Planning Services Sign Permit Review Form

Date of Submittal	Application Number	Applicant	Landowner
05-31-19 <small>* Revised plans submitted</small>	SIGN1904-0007	Debbie Landell	Par S Dev. Group LLC
Contact Person	Contact Number		
Debbie Landell	919-639-4666		
Sign Location	PIN Number		
72 Spring Hill Church Rd.	0518-80-5524

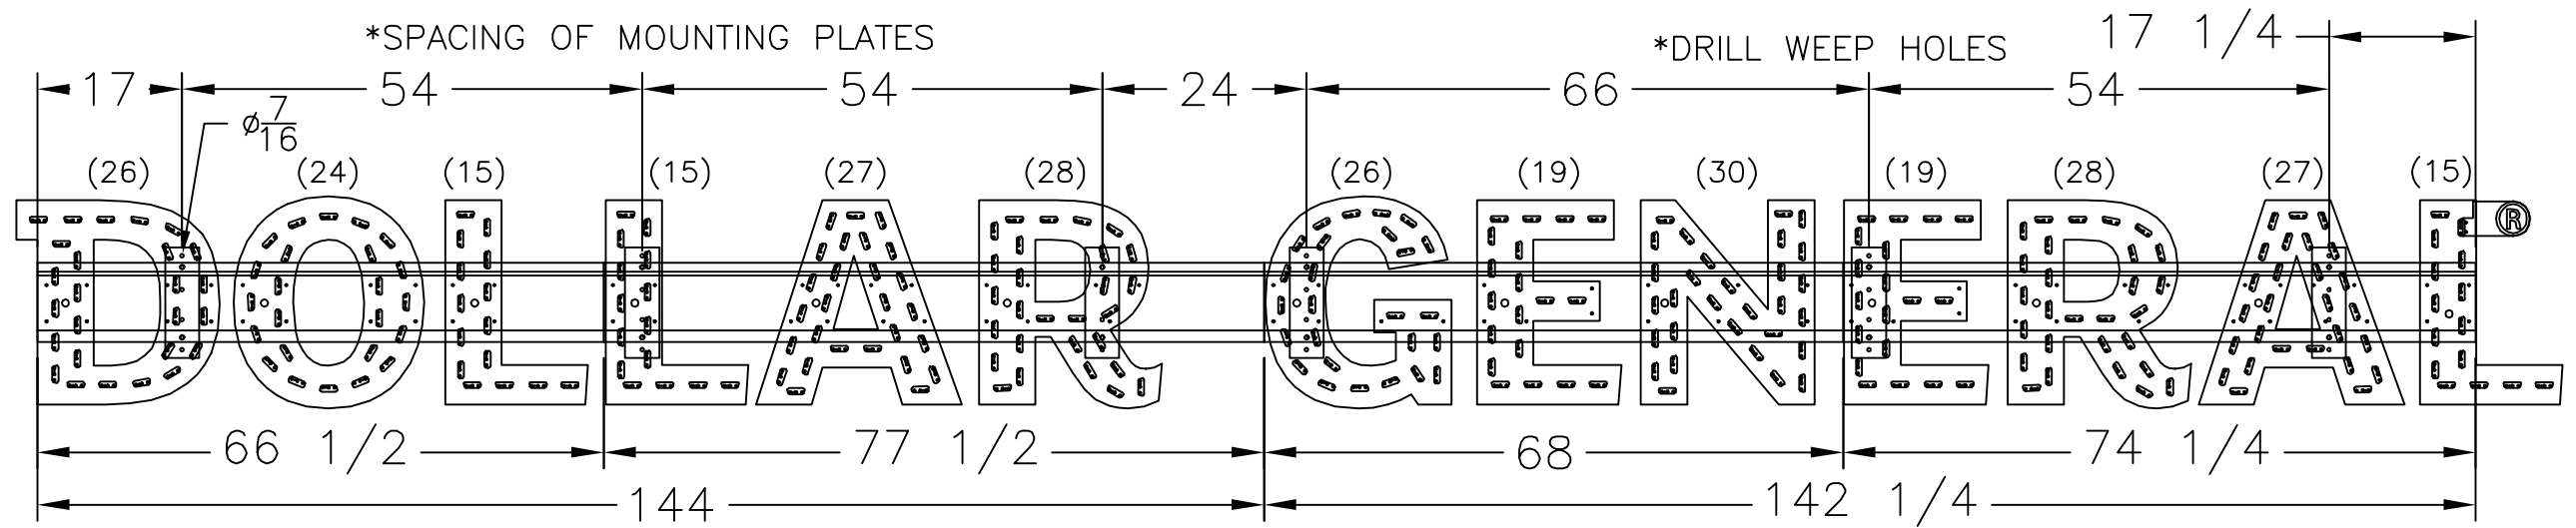
WALL SIGNS:

- South Elevation

Building width = 55 feet

Sign size = $24' 10\frac{3}{16}" \times 2'$

$$= 24.9 \times 2$$

$$= 49.8 \text{ sq. ft.} = \text{ok} \checkmark$$

- WEST ELEVATIONS

Building width = 114 feet

Sign size = $24' 10\frac{3}{16}" \times 2'$

$$= 24.9' \times 2'$$

$$= 49.8 \text{ sq. ft.} = \text{ok} \checkmark$$
